CITY OF ALBUQUERQUE

December 27, 2024

**Re: SW Premium Cannabis
5645 4TH St. NW
30-Day Temporary Certificate of Occupancy
Transportation Development Final Inspection
Architect's Stamp dated 10-20-22 (F14-D083)
Certification dated 12-03-24**

7 HANDICAP PARKING SIGN
SCALE: 3/4"=1'-0"

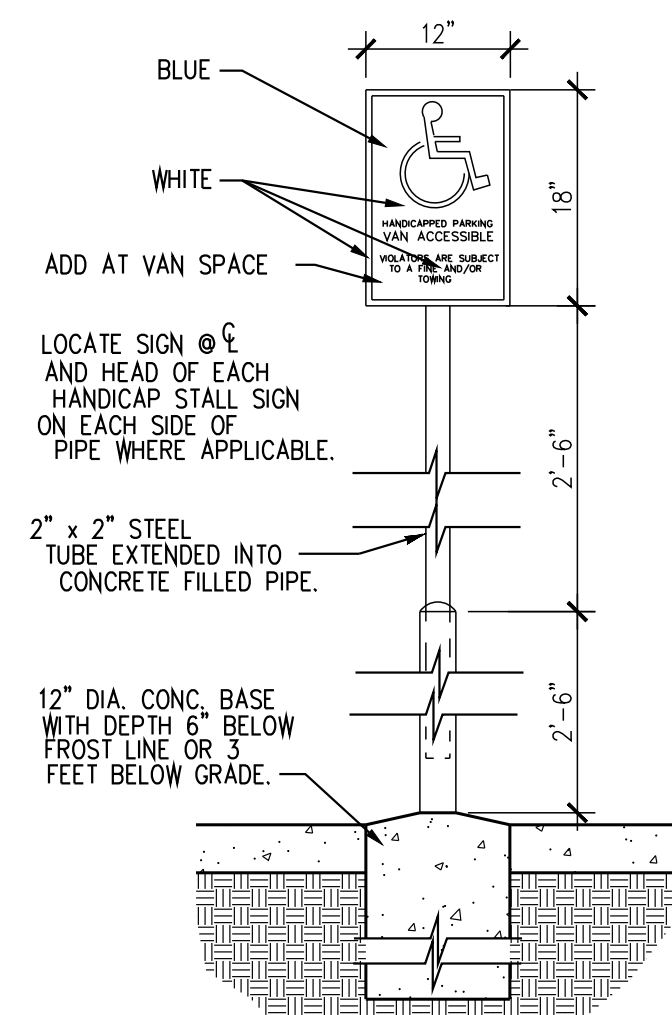
- The ADA accessible parking sign must have the required language per 66-7-352.4C NMSA 1978 **"Violators Are Subject to a Fine and/or Towing."** Please call out detail and location of signs.
- The ADA access aisles shall have the words "NO PARKING" in capital letters, each of which shall be at least one foot high and at least two inches wide, placed at the rear of the parking space so as to be close to where an adjacent vehicle's rear tire would be placed. (66-1-4.1.B NMSA 1978). An ADA aisle spot must be painted with blue stripes.
